Our Ref 20-2059  
Your Ref 19/01948/F

**Construction of a house and garage at land to the rear of 128 Lynn Road, Downham Market**

Please find attached a non-material amendment application for the above.

Drawing Title: Proposed Elevations, Roof
 Plan and Site Section

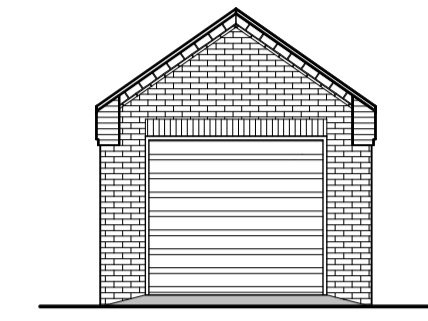
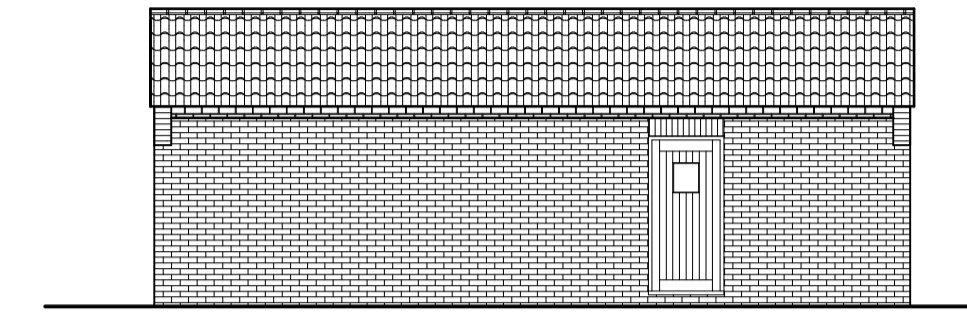
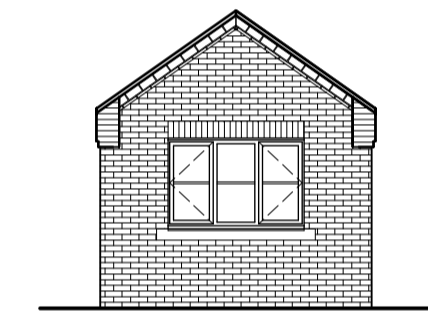
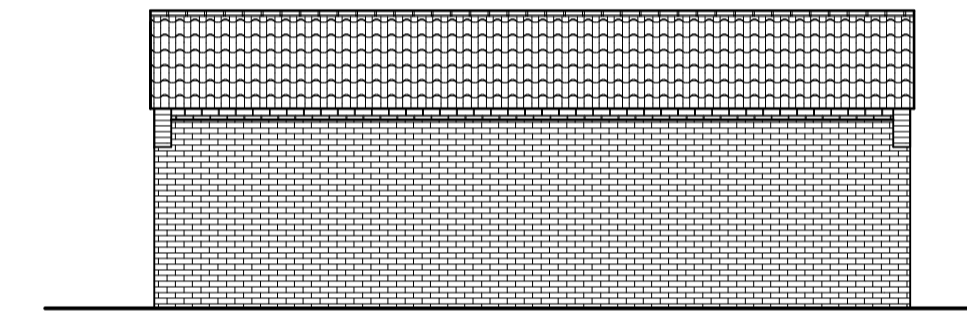
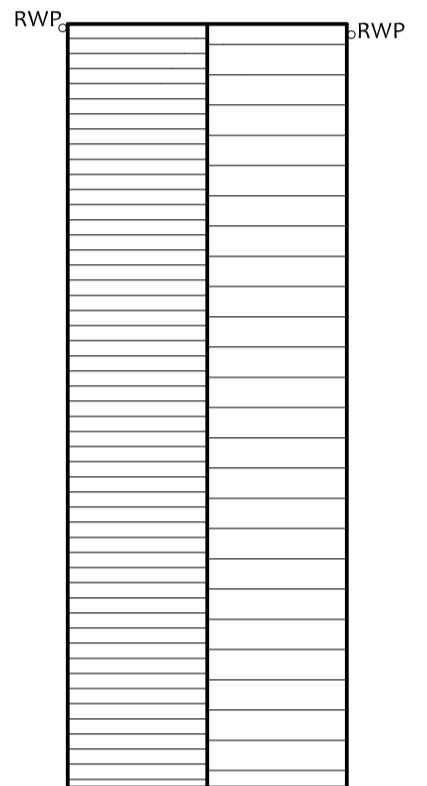
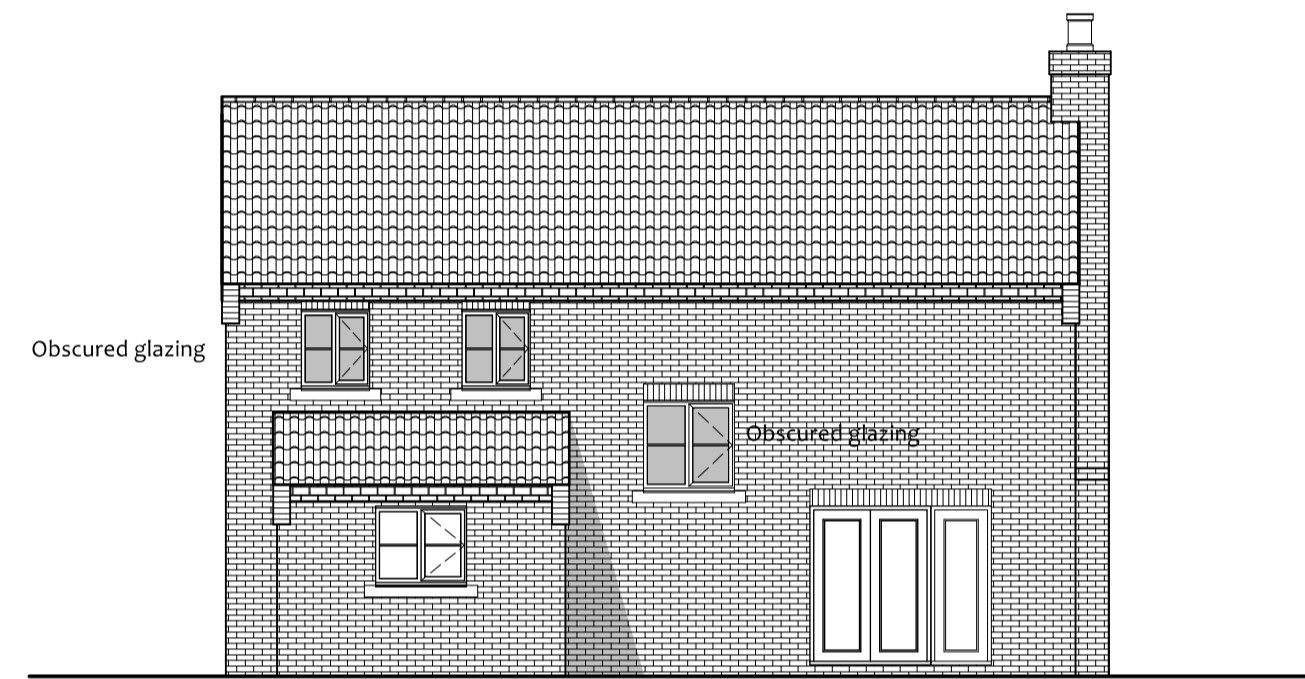
Unfortunately, due to a nationwide issue with the supply of building products and materials the bricks and roof tiles initially specified are currently not available.

The client would therefore like to change the bricks to Ibstock Athena, and the roof tiles to a Marley Modern smooth grey tiles or similar.

We have updated the proposed elevation plan 20-2059-5 to note this change.
